Date: 19 July 2021
Our ref: reference TBC
(NATIONALLY SIGNIFICANT INFRASTRUCTURE
PROJECT)

<p>DRAFT MITIGATION LICENCE APPLICATION STATUS: INITIAL DRAFT APPLICATION LEGISLATION: THE WILDLIFE AND COUNTRYSIDE ACT 1981 (as amended) NSIP: A47/A11 Thickthorn Junction SPECIES: Water vole</p>

Thank you for your draft water vole mitigation licence application in association with the above NSIP site, received in this office on the 27th May 2021. As stated in our published guidance, once Natural England is content that the draft licence application is of the required standard, we will issue a 'letter of no impediment'. This is designed to provide the Planning Inspectorate and the Secretary of State with confidence that the competent licensing authority sees no impediment to issuing a licence in future, based on information assessed to date in respect of these proposals.

Culvert under A11 lined entirely with concrete, no natural features.

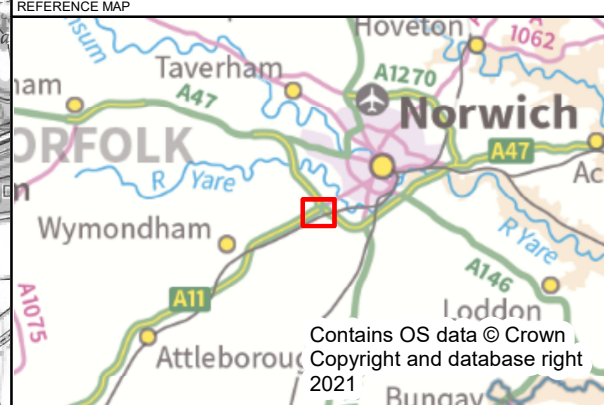
(a) The A11 underpass for the Stream is to be extended by some 10m (from an existing width of c.30m). The Stream will be locally de-watered during these works which will create restrictions in the movement of riparian mammals (especially Otters). There is little information about the underpass size (it appears from aerial photos to be quite generous). Appendix F p.44 states that this extension will use the same aperture size.
